WILLOWTREE PLANNING

REF: WTJ20-395

Wentworthville Northside West Clinic Extension SSD-17899480

TABLE 1. DPE COMMENTS		
A. 10 October 2022 Comments		Applicant Response
1.	Provide a statement from the arborist clearly detailing the consideration of each individual matter listed in Clause 3.3.4 (b) to (h) of AS4970-2009 for trees 41, 48 and 49, to support the conclusion that each of the trees will remain viable for retention.	Please refer to the attached Arborist Statement from Birds Tree Consultancy dated the 14th October.

This design complies with: AS3500.3:2021	NORTHSIDE WEST CLINIC			
	PIPE LAYOUT - GROUND FLOOR			
	Size A3	Status APPROVED FOR SUBMISSION	Drwg No. DR-101	Rev. 3

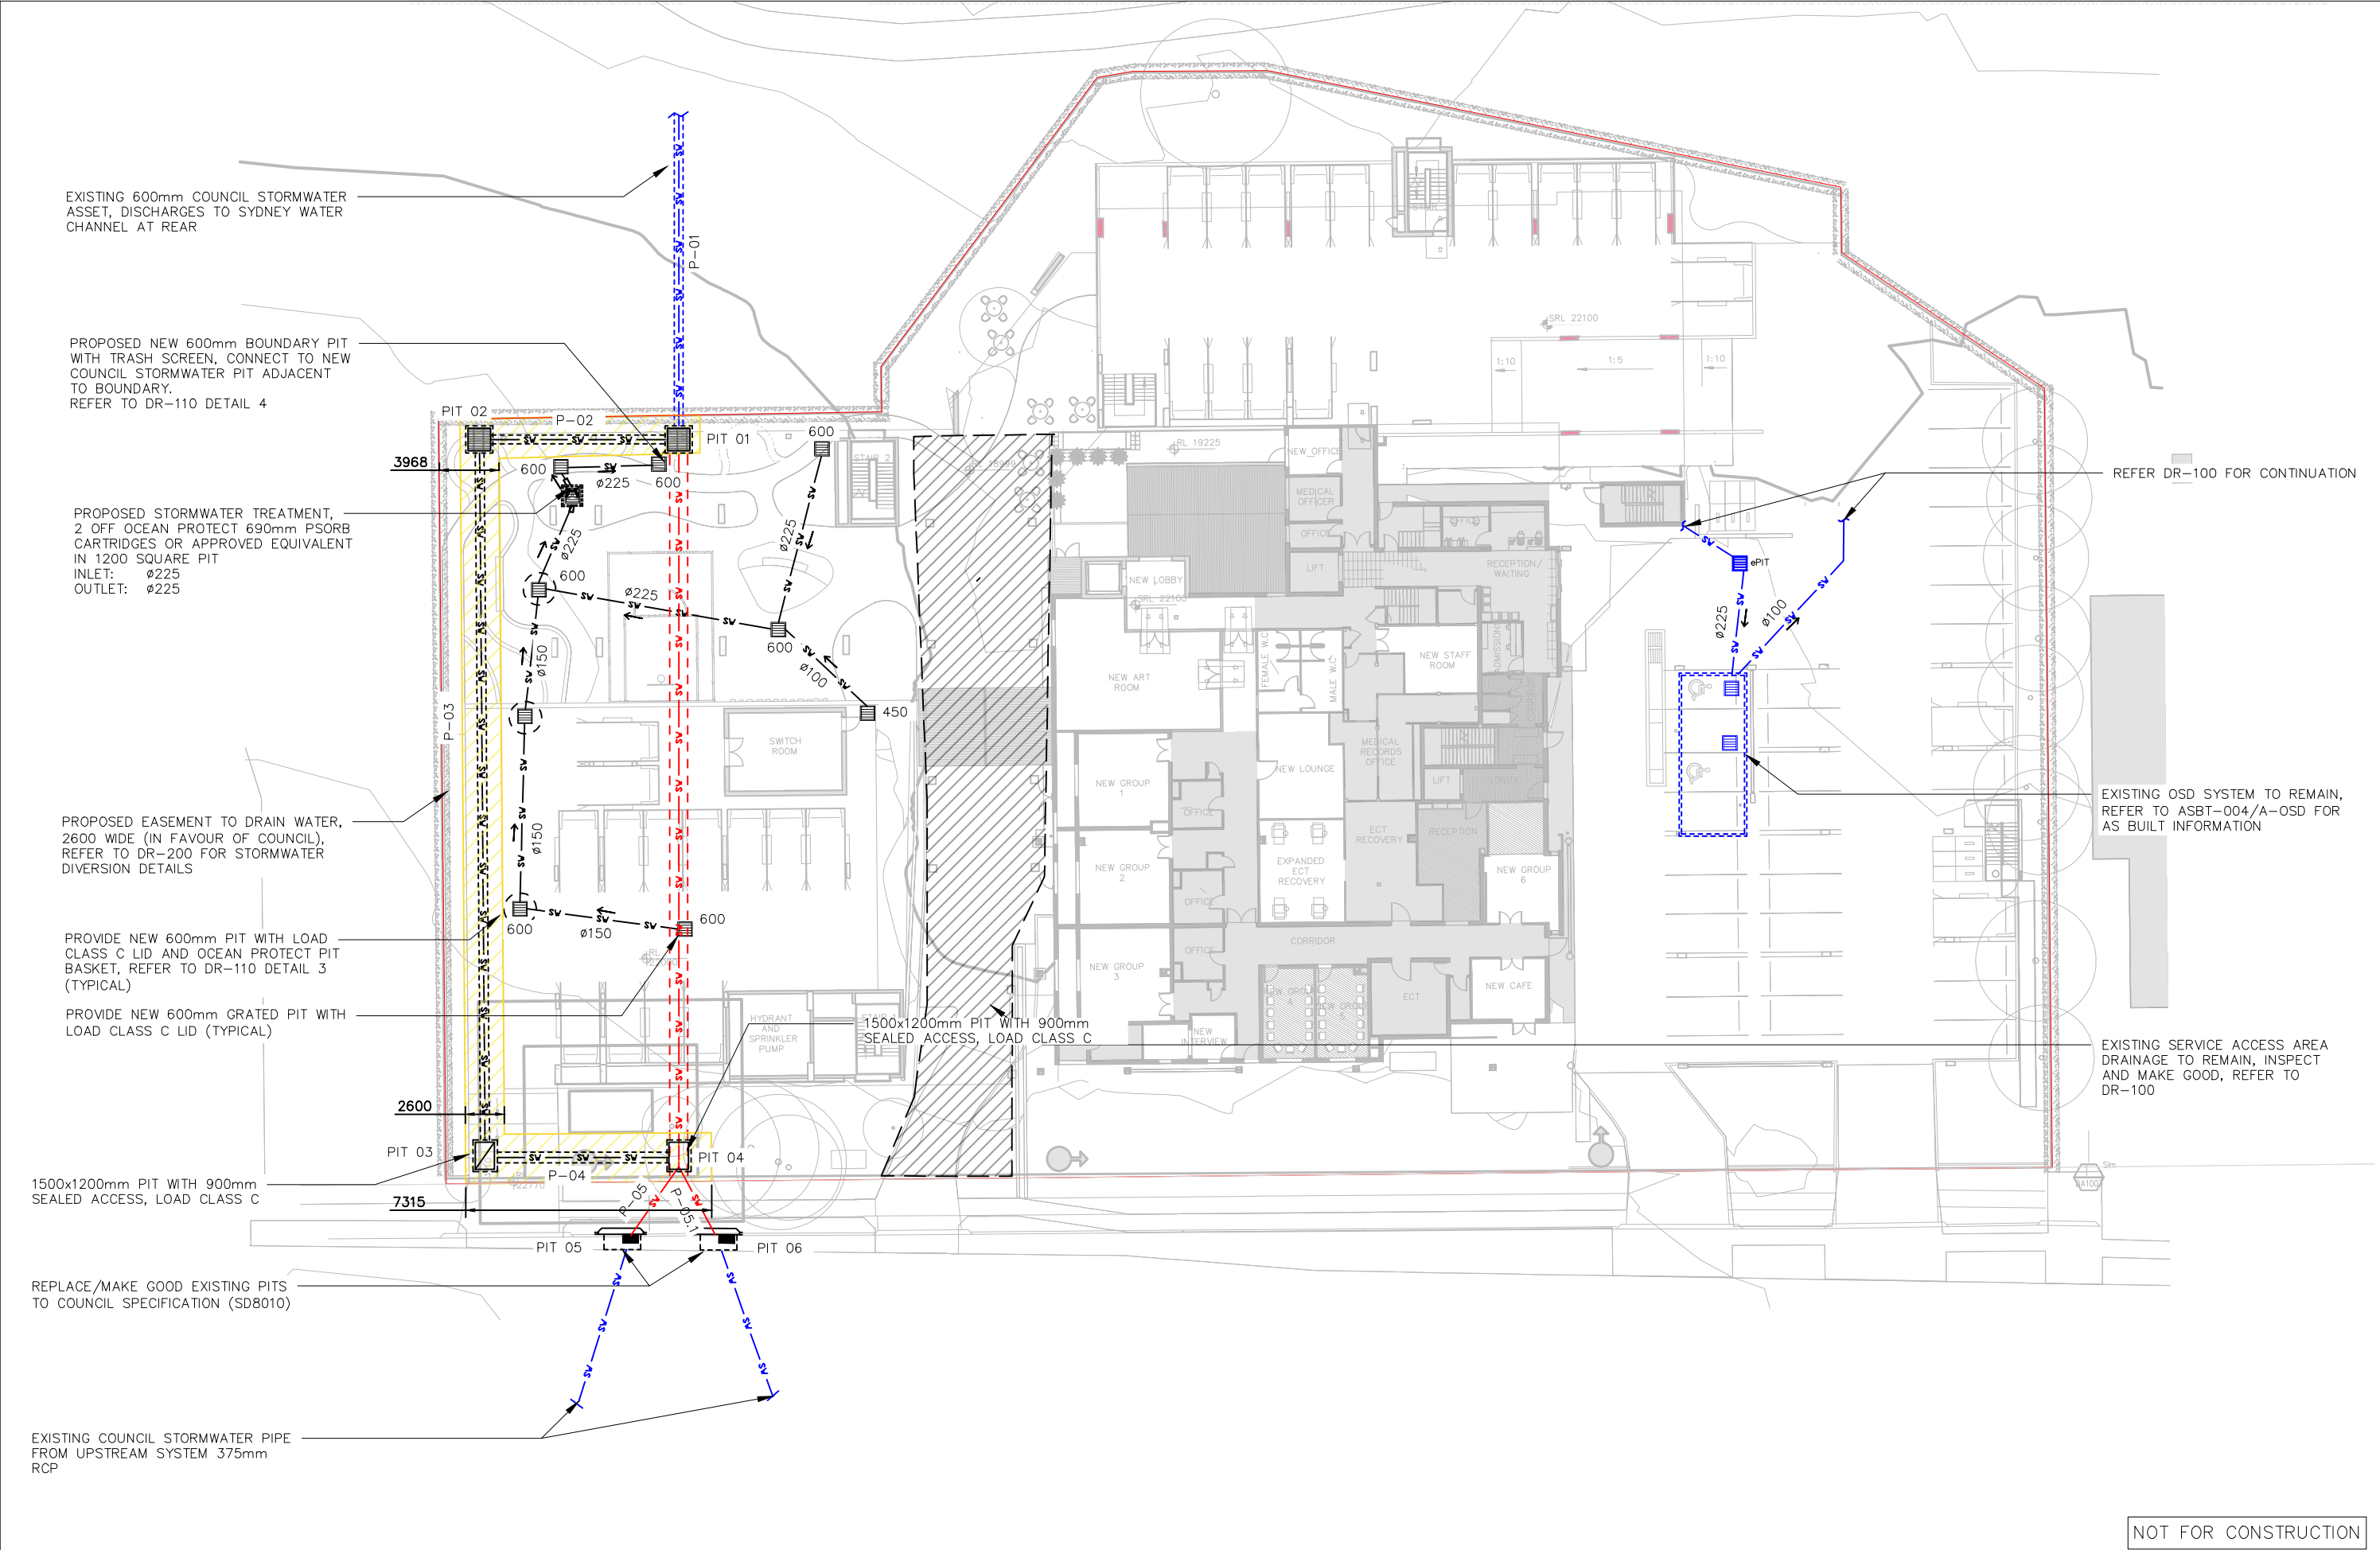
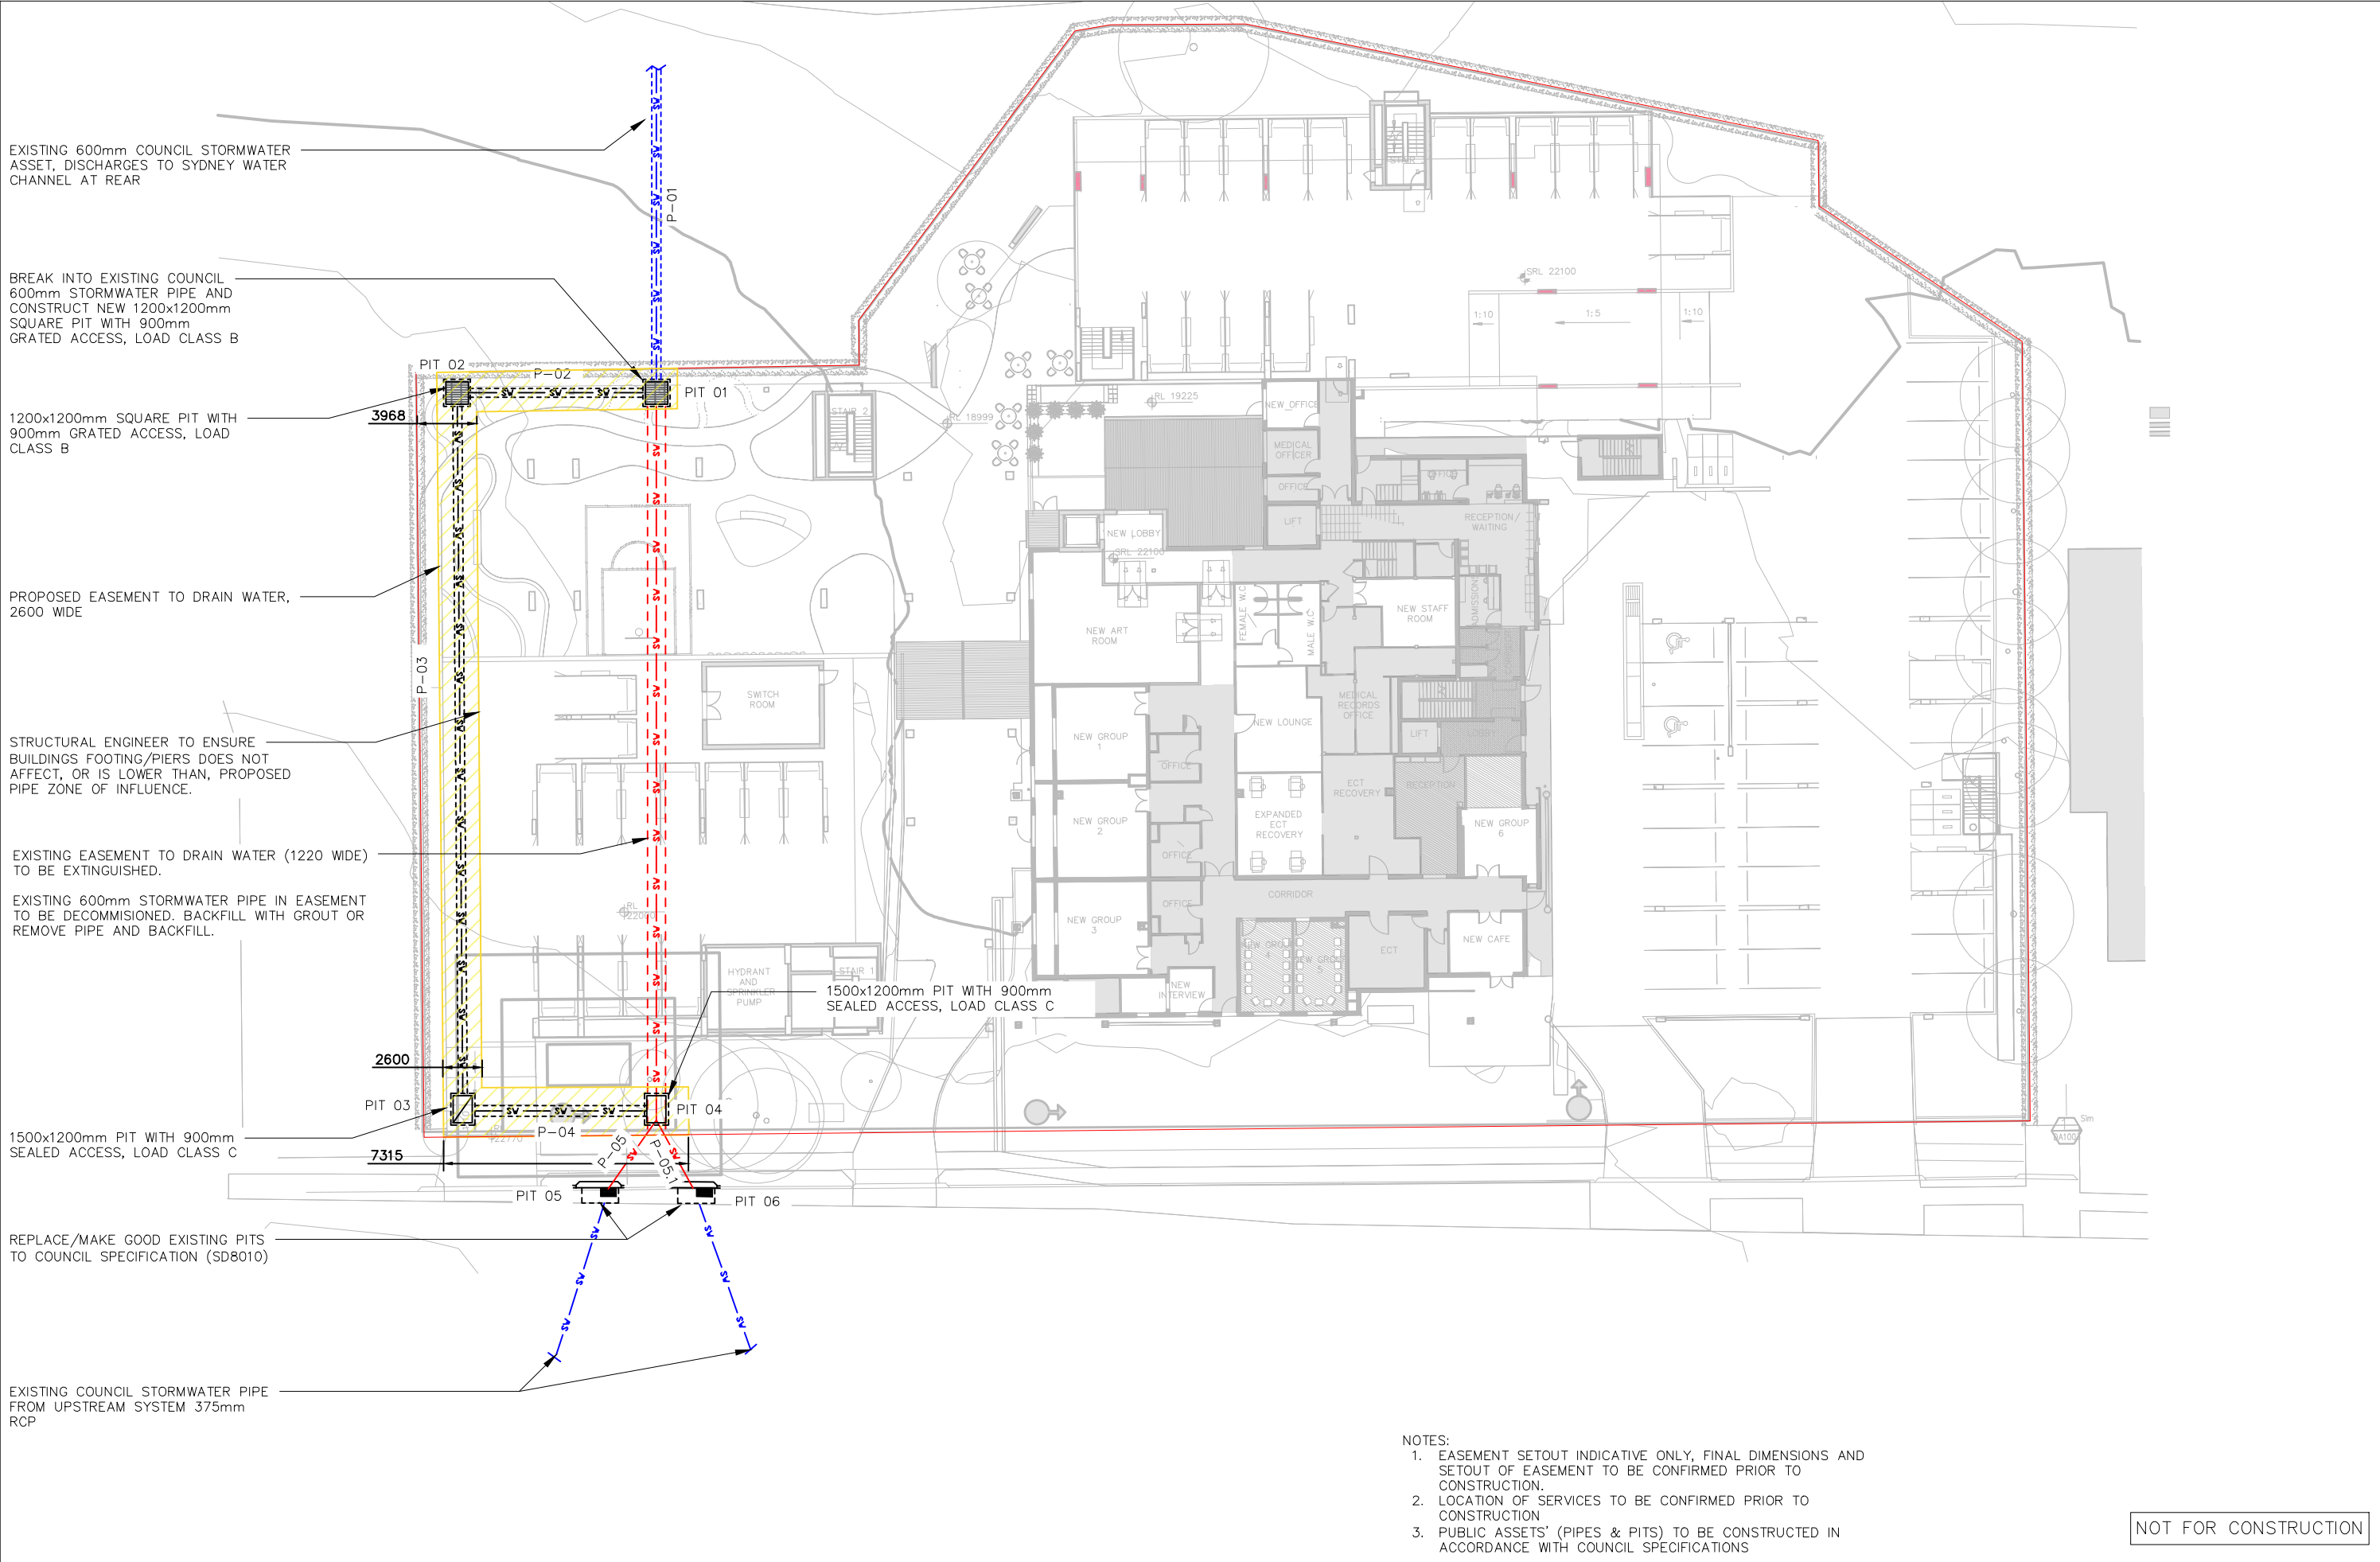
3.	The proposed substation is shown as being located within Council's stormwater easement on drawings DR-101 and DR-200. All drawings must clearly demonstrate that the substation is not withing the easement.	Please refer to attached Updated Stormwater Plans DR-101 and DR-200.
